**WEST SUSSEX COUNTY COUNCIL
INFRASTRUCTURE CONSULTATION**

DATE: 23rd February 2010

SUBJECT: BN/27/09 - Outline application for demolition of all existing buildings/structures & redevelopment with up to 100 dwellings (including up to 40 affordable homes) together with associated open space, landscaping & access improvements (This is a Departure from the Development Plan)

Angels & Hyde Nurseries, Yapton Road, Barnham, West Sussex, PO22 0AY

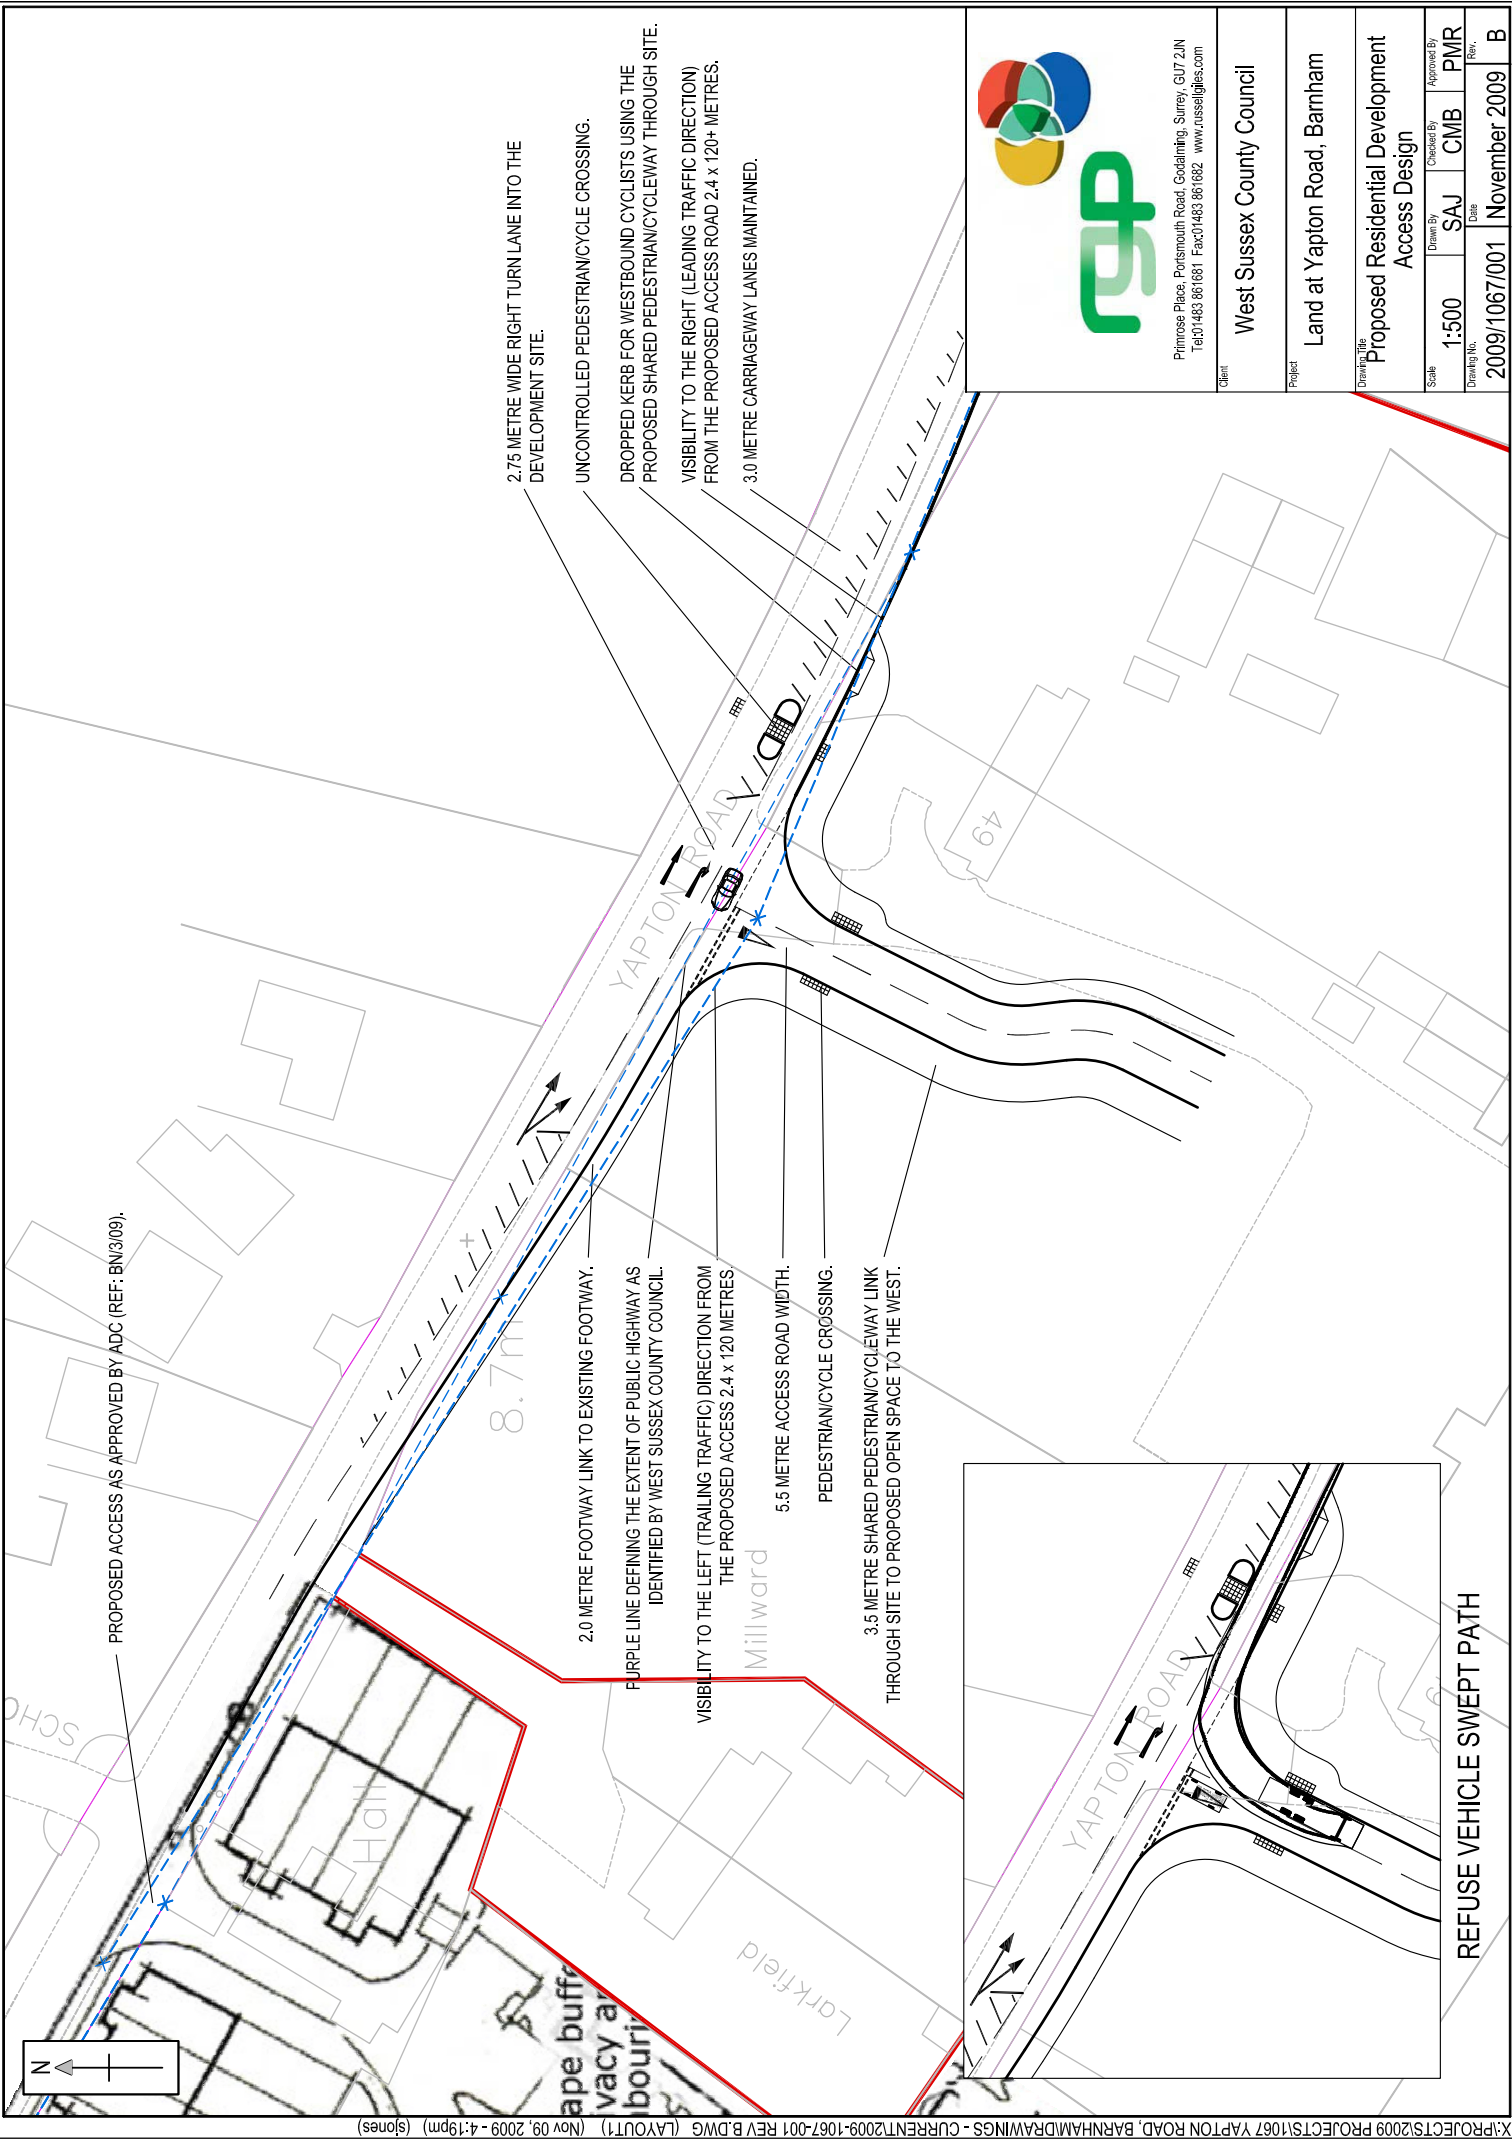
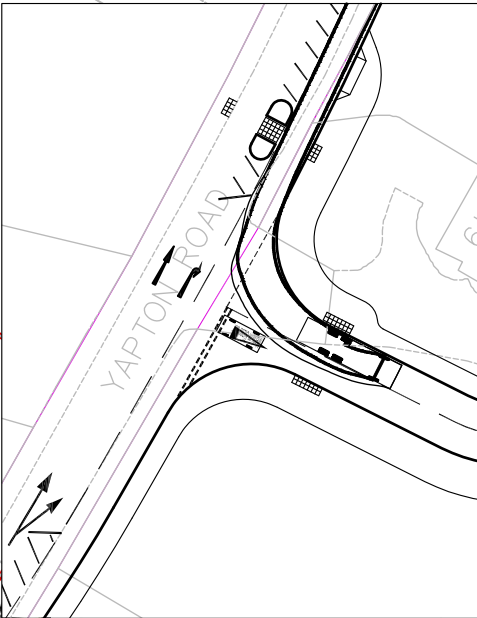
The access to the site is proposed to be via a new priority junction with Yapton Road with a right turn lane facility which provides visibility in excess of the current requirements for a 30mph speed limit.

The proposed site access also provides for a pedestrian footway link to the exiting footway west on Yapton Road, Shared use Pedestrian / Cycle route from Yapton Road through the internal layout and an uncontrolled pedestrian / cycle refuge crossing incorporated within the right turn

lane. The access design is shown on Drawing No. 2009/1067/001 Rev B (Proposed Residential Development Access Design).

At paragraph 5.1.3 of the Transport Assessment the applicants state the proposed access / right turn lane has been designed in accordance with national guidance in Design Manual for Roads and Bridges TD 42 / 95 (geometric design of Major / Minor Priority Junctions). The applicants have not identified any departures from standard in the design. Should any departures be identified at detailed design / S278 / S38 stage, the County Council will require the applicant to revise the design to accord with standards.
